CITY OF ALBUQUERQUE

Re: Coal Flats
1203 Coal Ave. SE
Traffic Circulation Layout
Engineer's/Architect's Stamp 6-9-2023 (K15D011)

Based upon the information provided in your submittal received 6/23/2023, the above referenced plan cannot be approved for Building Permit until the following comments are addressed:

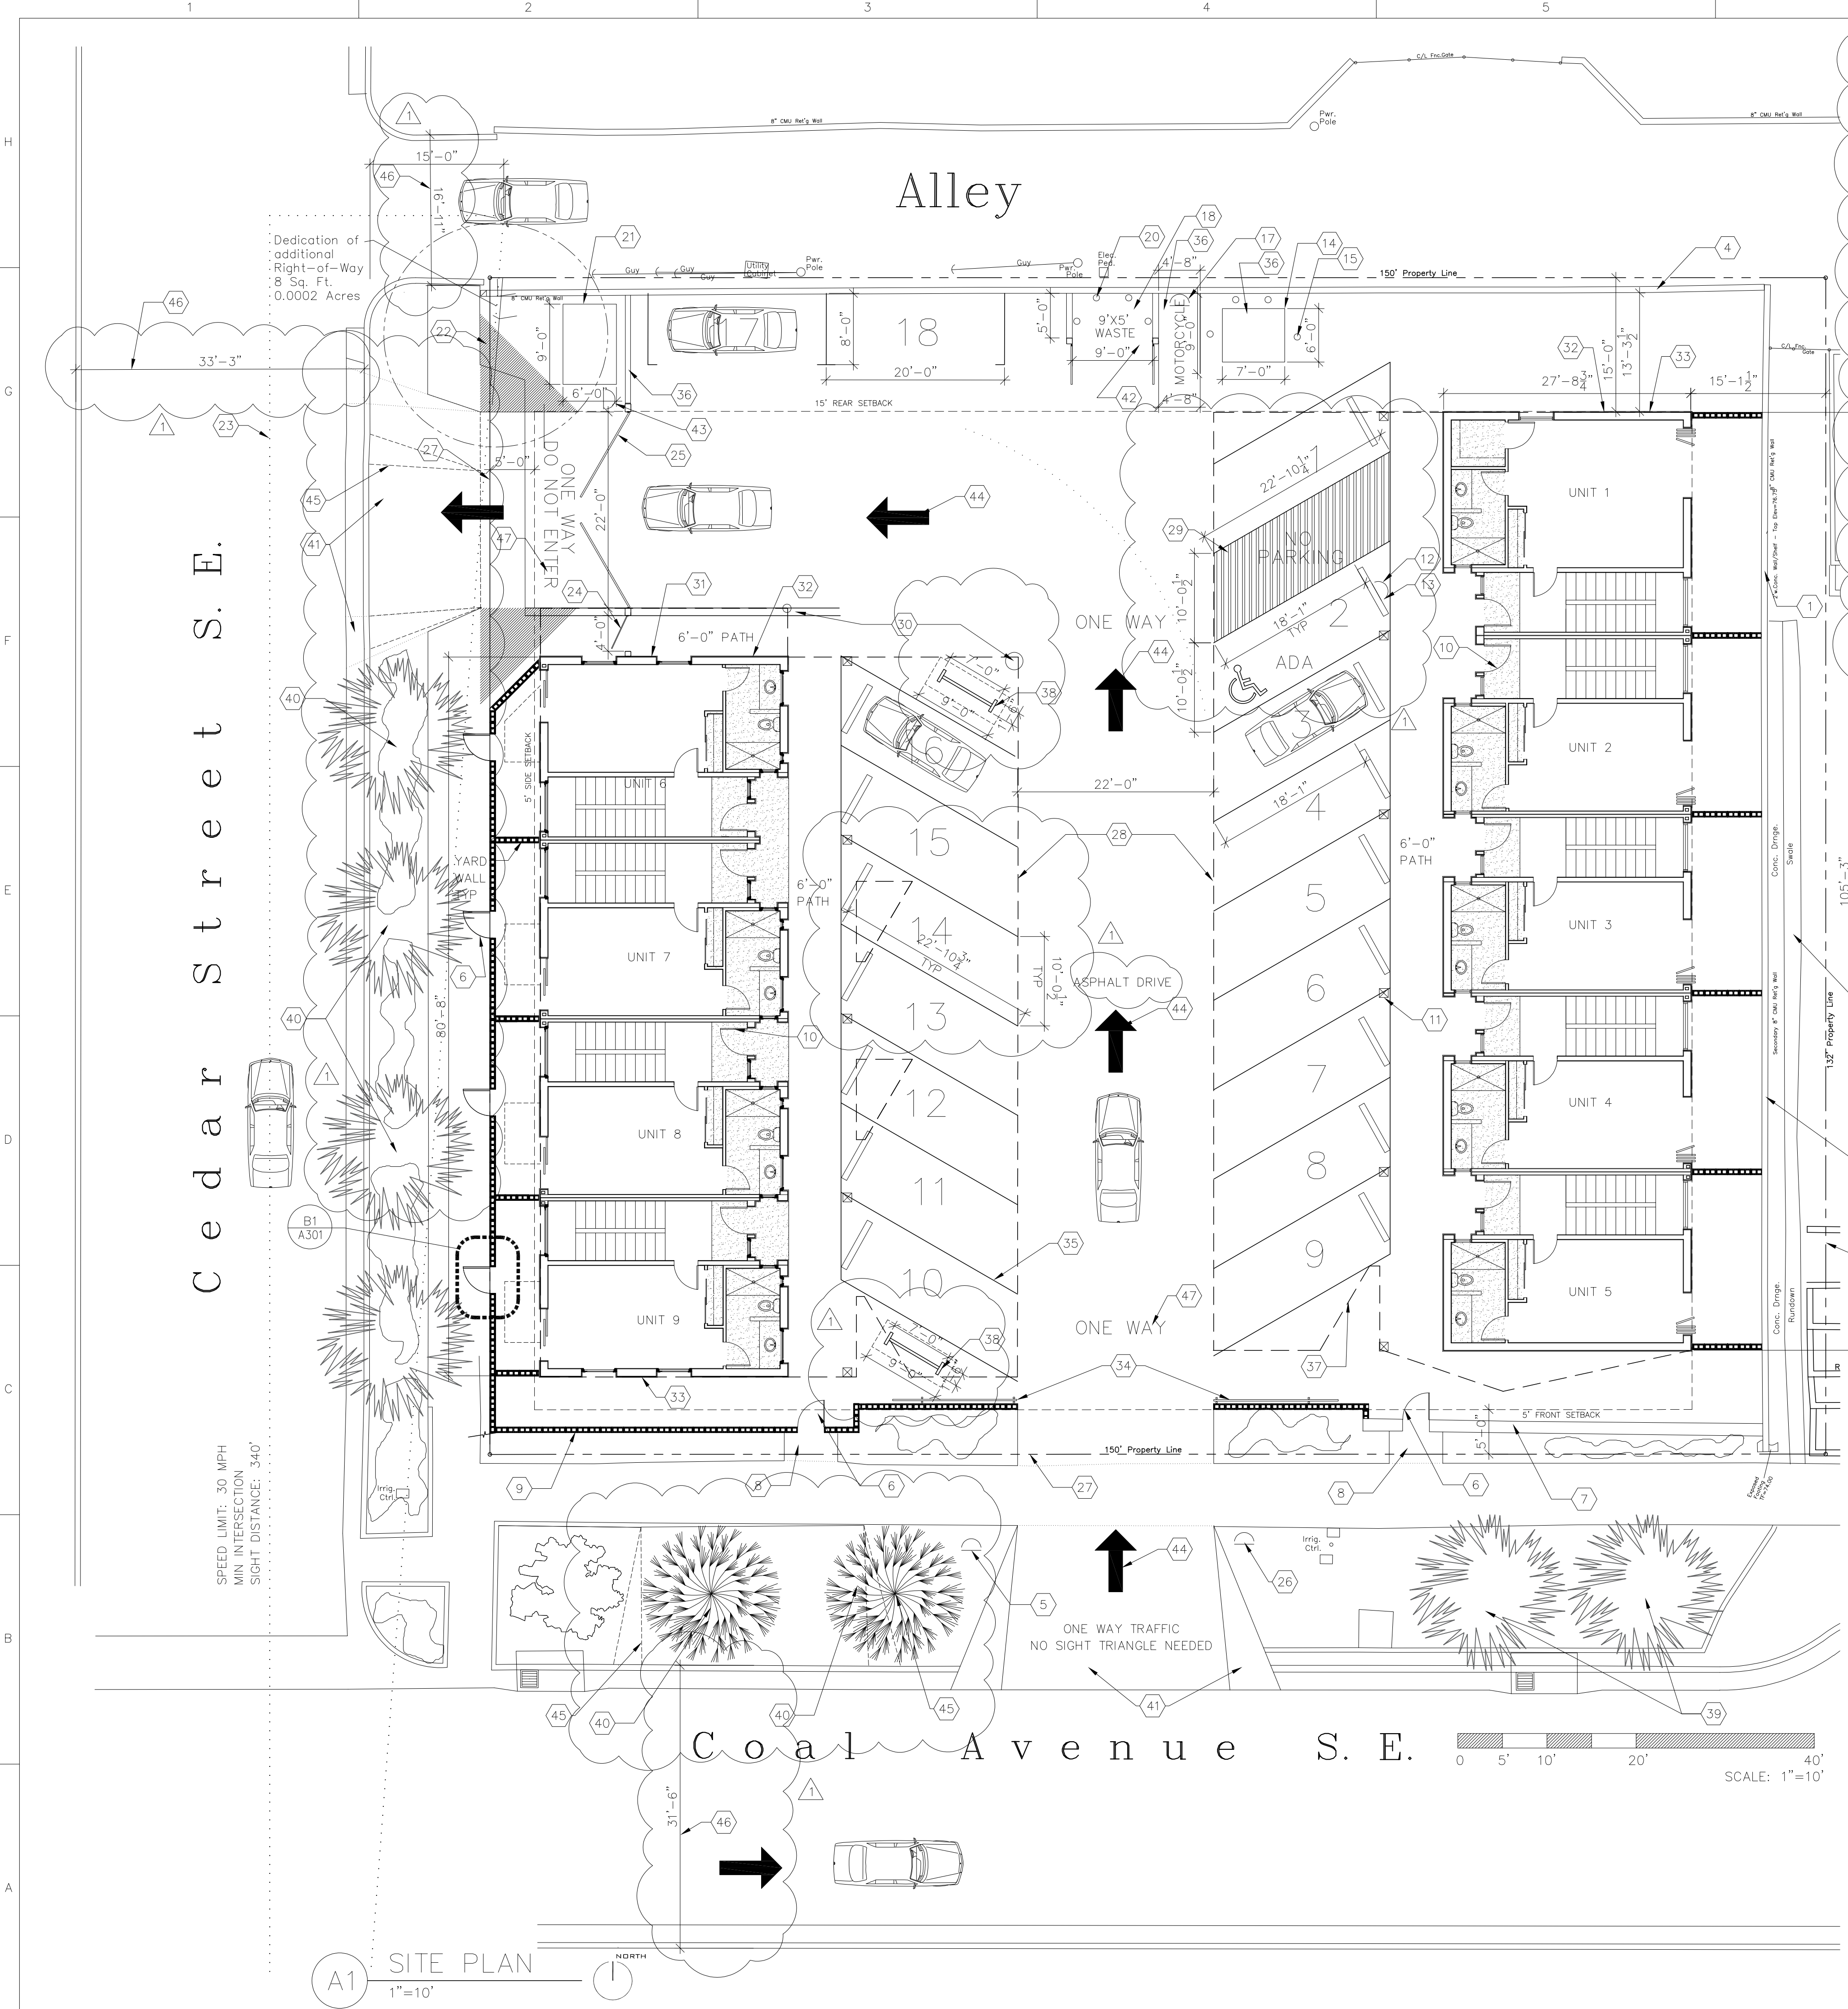
1. Identify the right of way width and street widths on the alley, Coal and Cedar.
2. Please list the width and length for all proposed parking spaces. You show width of vehicle spaces and depth of motorcycle, but we need width and depth of both. We also need the width of the ADA access aisle shown.

3. The ADA accessible parking sign must have the required language per 66-7-352.4C NMSA 1978 **"Violators Are Subject to a Fine and/or Towing."** Please call out detail and location of signs.

4. The ADA access aisles shall have the words **"NO PARKING"** in capital letters, each of which shall be at least one foot high and at least two inches wide, placed at the rear of the parking space so as to be close to where an adjacent vehicle's rear tire would be placed. (66-1-4.1.B NMSA 1978)

5. Motorcycle parking spaces shall be designated by its own conspicuously posted upright sign, either free-standing or wall mounted per the zoning code.

6. All bicycle racks shall be designed according to the following guidelines:
 - a. The rack shall be a minimum 30 inches tall and 18 inches wide.
 - b. The bicycle frame shall be supported horizontally at two or more places. Comb/toaster racks are not allowed.

- c. The rack shall be designed to support the bicycle in an upright position. See the IDO for additional information.
 - d. The rack allows varying bicycle frame sizes and styles to be attached.

- e. The user is not required to lift the bicycle onto the bicycle rack.
 - f. Each bicycle parking space is accessible without moving another bicycle.

7. Bicycle racks shall be sturdy and anchored to a concrete pad.
8. A 1-foot clear zone around the bicycle parking stall shall be provided.

9. Bicycle parking spaces shall be at least 6 feet long and 2 feet wide.
10. Refuse vehicle maneuvering shall be contained on-site. The refuse vehicle shall not back into the public right of way. Please provide a copy of Solid Waste approval.

11. Please provide a copy of Fire Marshall approval.
12. It is not apparent what type of pavement surface is being proposed. A hard driving surface will be required as part of this proposed project for parking area and drive aisles.

13. All one-way drives shall have "One Way" and "Do Not Enter" signage and pavement markings. Please show detail and location of posted signs and striping. Please move the One Way sign at the exit out of the sidewalk.

14. For the clear sight triangle add the following note to the plan: "Landscaping and signage will not interfere with clear sight requirements. Therefore, signs, walls, trees, and shrubbery between 3 and 8 feet tall (as measured from the gutter pan) will not be acceptable in the clear sight triangle.

15. Please specify the City Standard Drawing Number when applicable.
16. Work within the public right of way requires a work order with DRC approved plans.

17. Provide notes showing what work is included and on the work order and the private work on site.
18. Please add a note on the plan stating "All improvements located in the Right of Way must be included on the work order."

19. Unused curb cuts must be closed and replaced with sidewalk and curb & gutter. Please show curb cuts to be closed. A build note must be provided referring to the appropriate City Standard drawing.

20. Add a note stating "All broken or cracked sidewalk must be replaced with sidewalk and curb & gutter." A build note must be provided referring to the appropriate City Standard drawing.
